## PLAN DETAILED REPORT MINOR\_PLT-2025-00036 FOR CITY OF ALBUQUERQUE

**Description:** Minor subdivision to create two lots from one, along existing residential lines. Variances for setbacks and sizing were approved. 5' PUE and 5' Private SAS easement granted with plat.

**Re: Final Plat for Proposed Minor Subdivision Plat Lot 12, Block 10, Eastern Addition**

The sketch plat review held March 19, 2025 under PS-2025-00047 are addressed below:

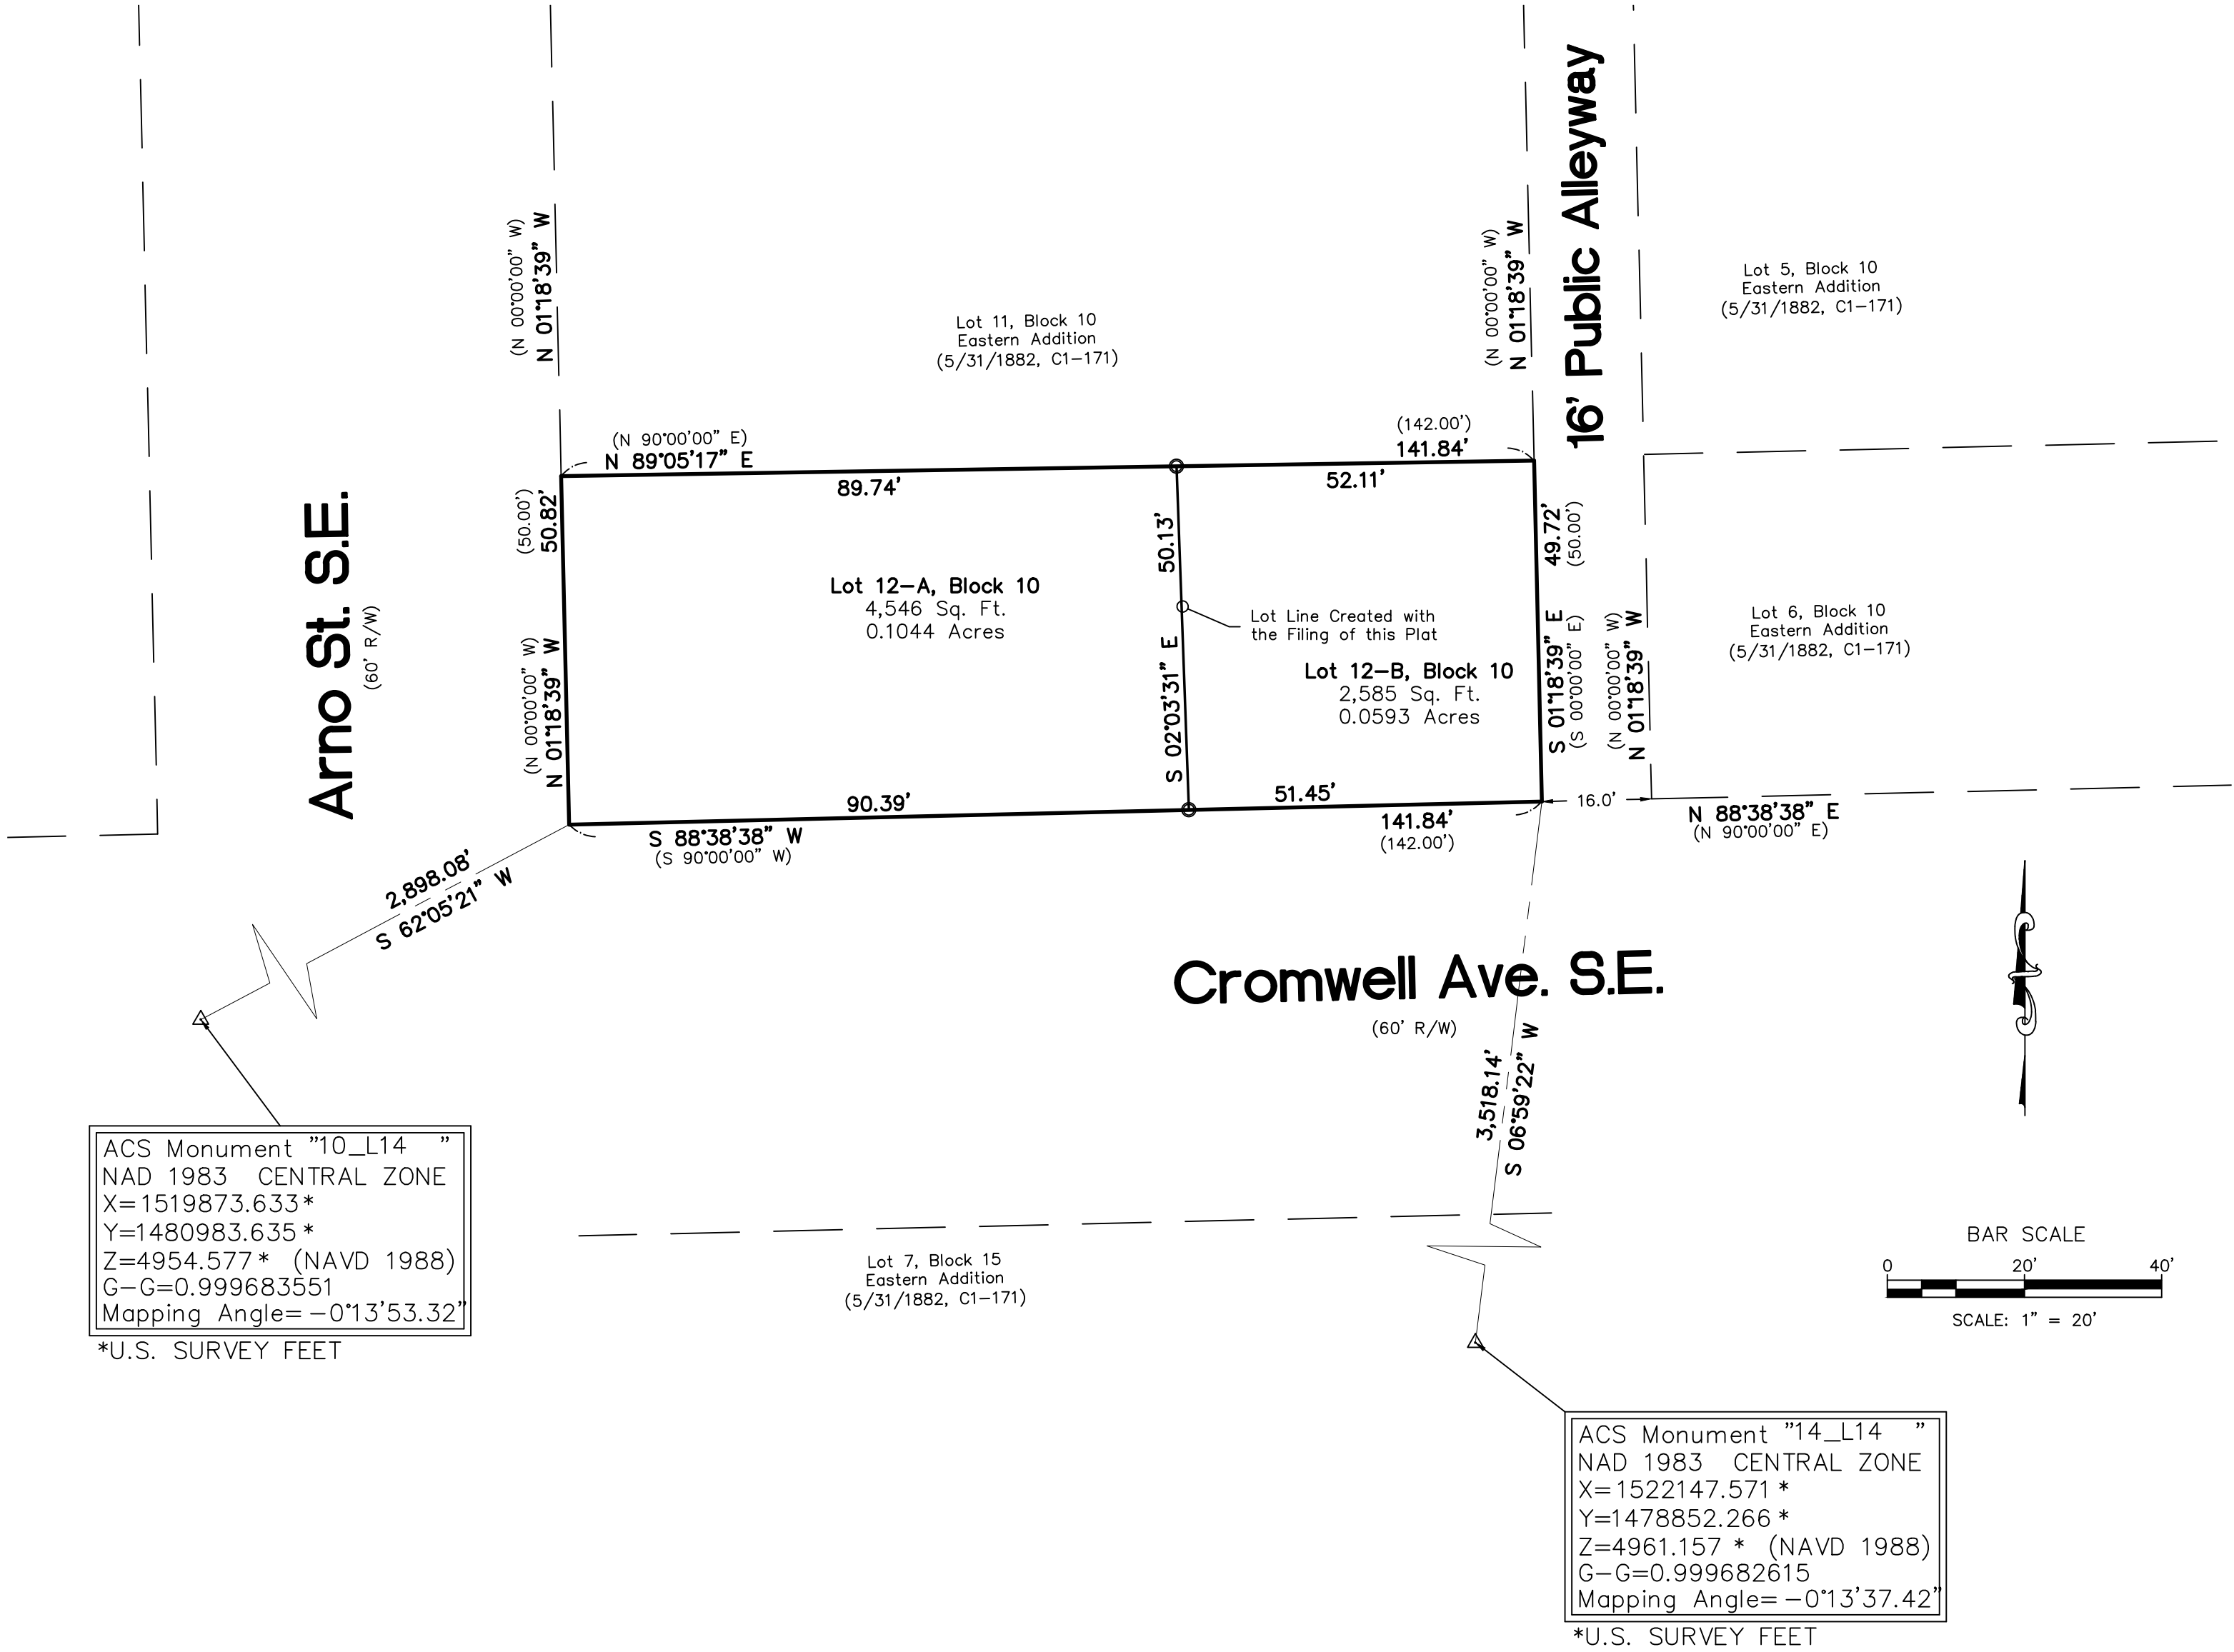
1. Sidewalks and buffers are adequate. The alley is shown at 16' wide, where all alleys are required to be 20' wide. ROW dedication is required. If you are unable to dedicate the ROW for the alley, you may request a determination to allow it to remain as is

Noted, we provide justification for a determination to allow alleyway to remain as-is with the application materials.

Drawing file: PR-2025-020033_PA-2025-00047_March_19_2025 (Sketch) / Site sketch showing existing features-2025-03-10-250176_SS_REV_v1.pdf

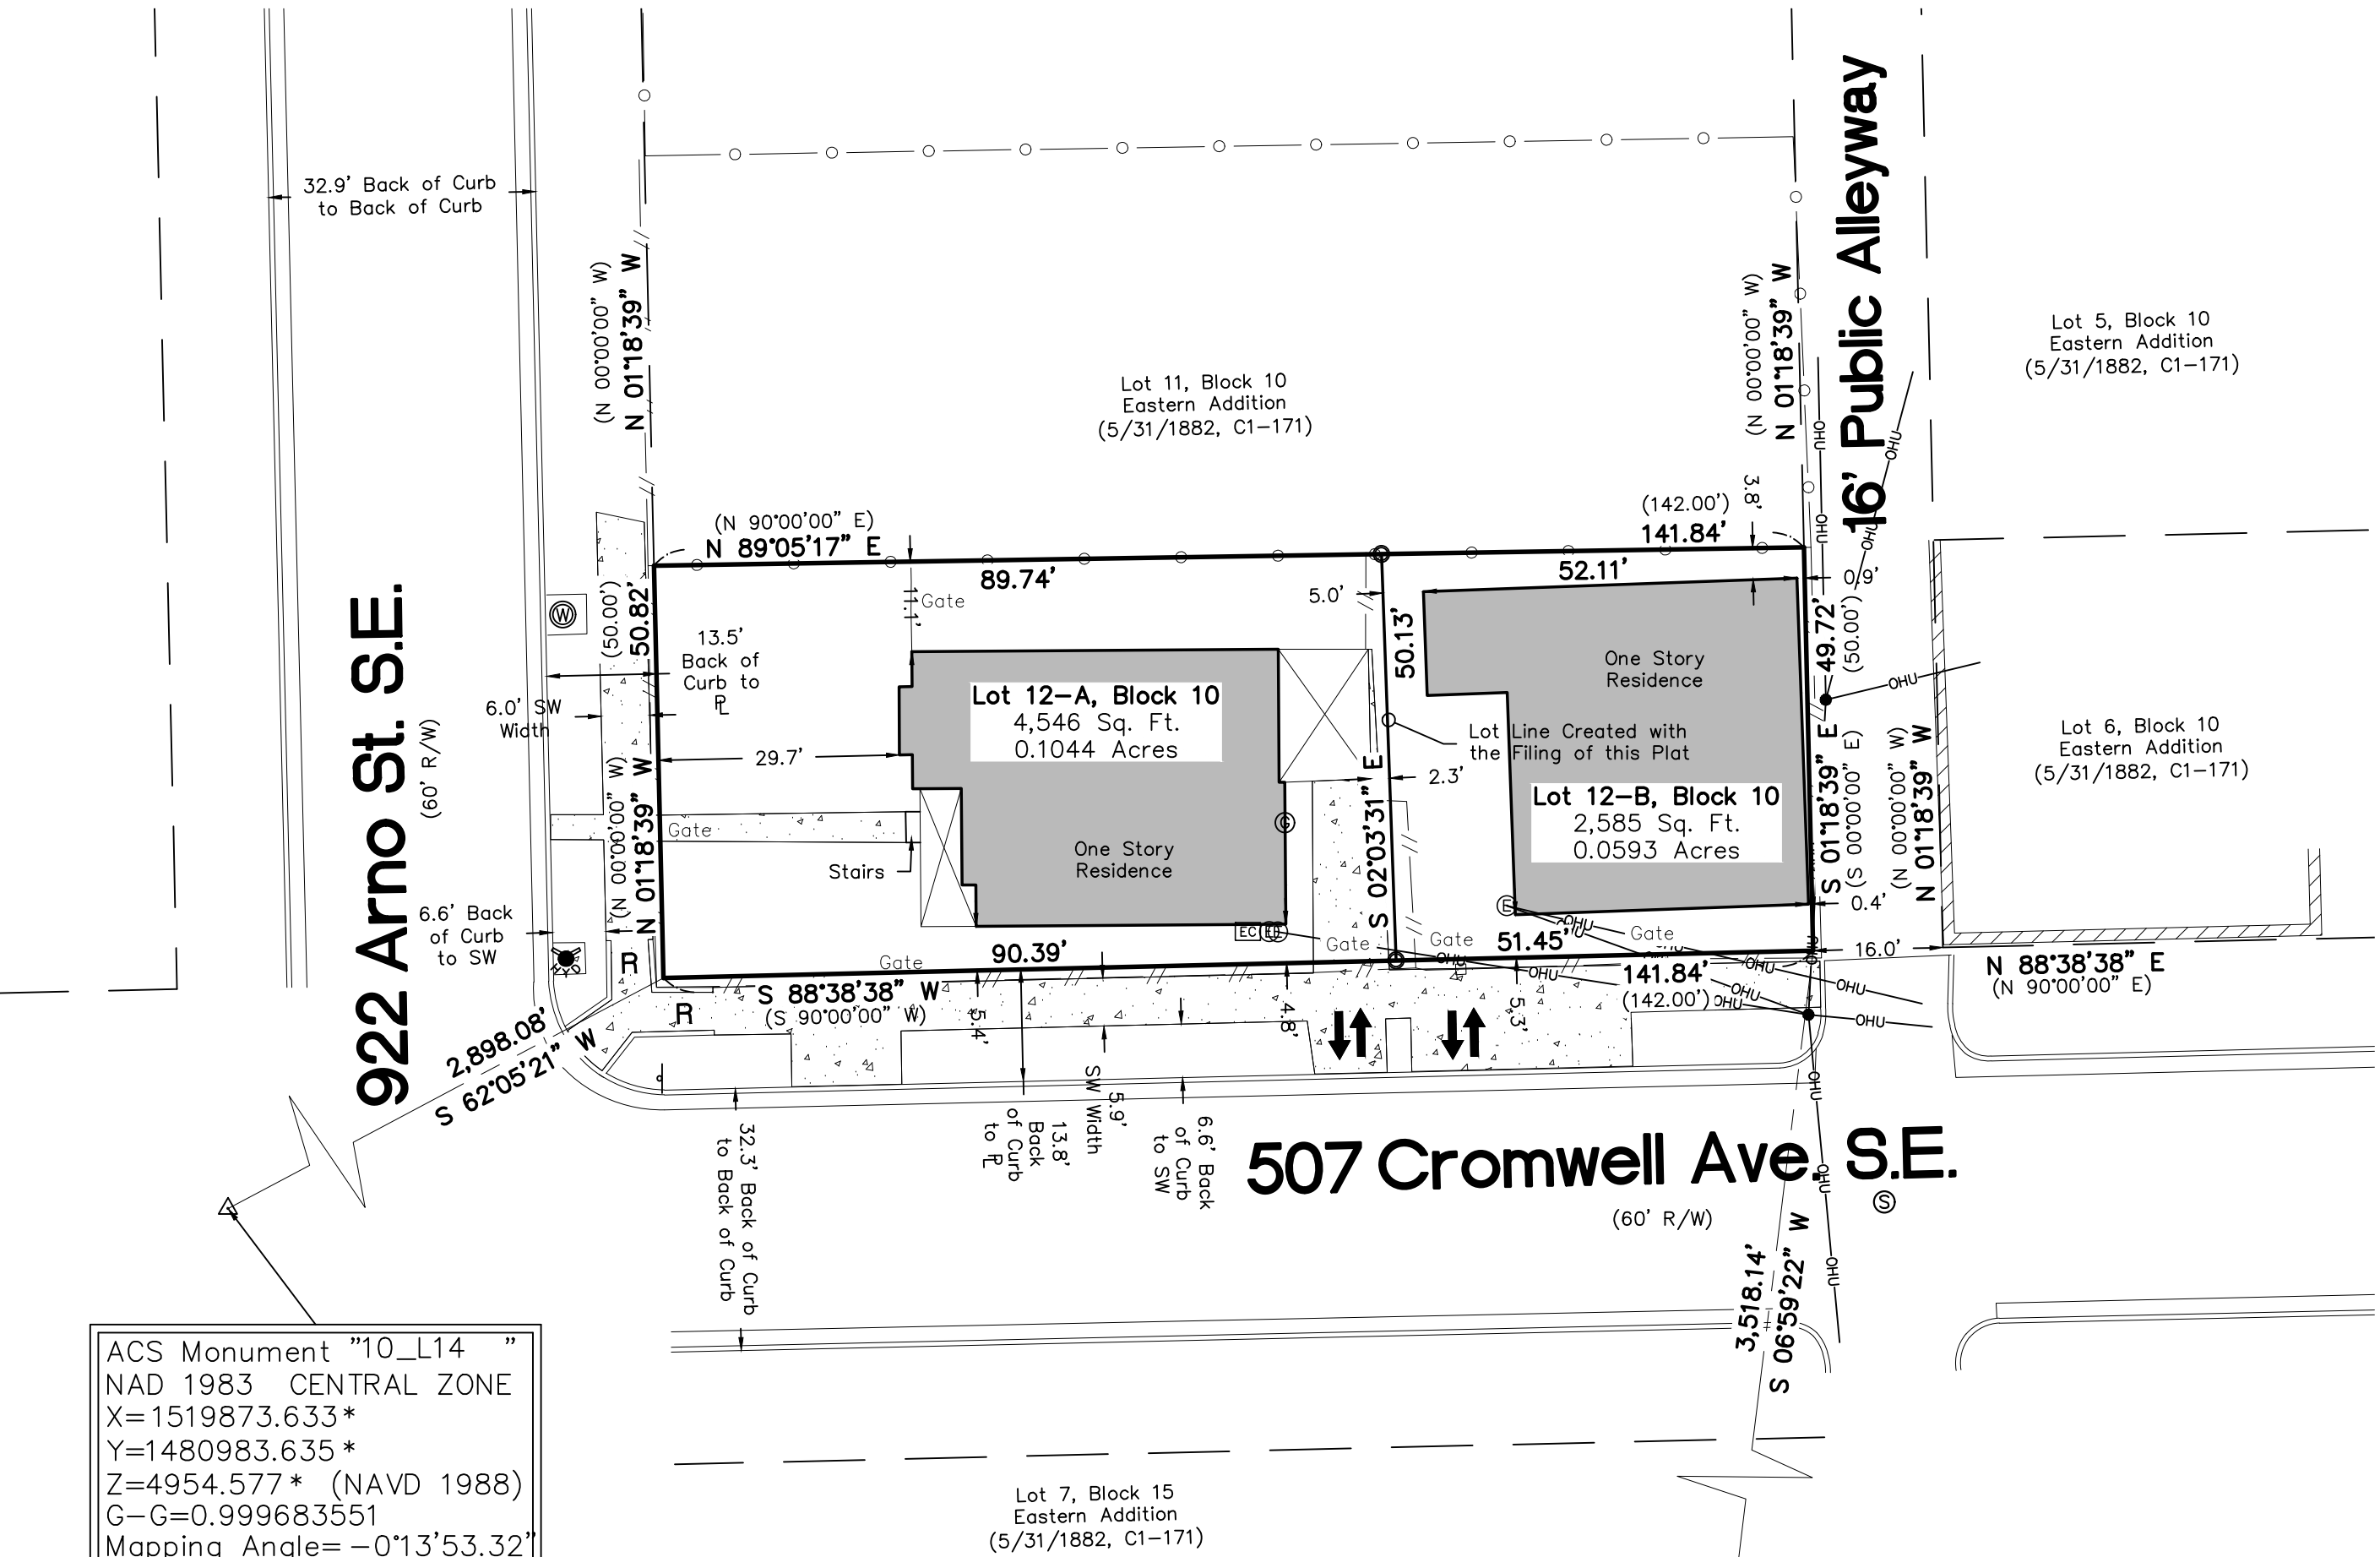
1. The 922 Arno St SE residence appears to have an existing ABCWUA water and sewer account, possibly two accounts, but neither are near the 507 Cromwell Ave SE residence. It may be that the residence at 507 Cromwell Ave SE is sharing the account(s). If this is the case, separate services and accounts will need to be established for the subdivided lots with existing dwellings prior to plat approval.

6. The surveyor shall field verify the location of existing private water and/or private sanitary sewer services to determine if private service easements are needed to preserve the existing service(s) for the newly created lots. The width of the private service easement shall be determined by the engineer or surveyor.

7. Proper private water and/or private sanitary sewer service easements shall be granted for access to public waterline and/or public sanitary sewer for proposed lots which do not have direct

Noted, water and sewer lines are separate as shown in attached site sketch. There is a private service easement for sanitary sewer [2], granted with this plat. Waterlines fall within right-of-way and are provided by separate water meters in the residences respective frontages.
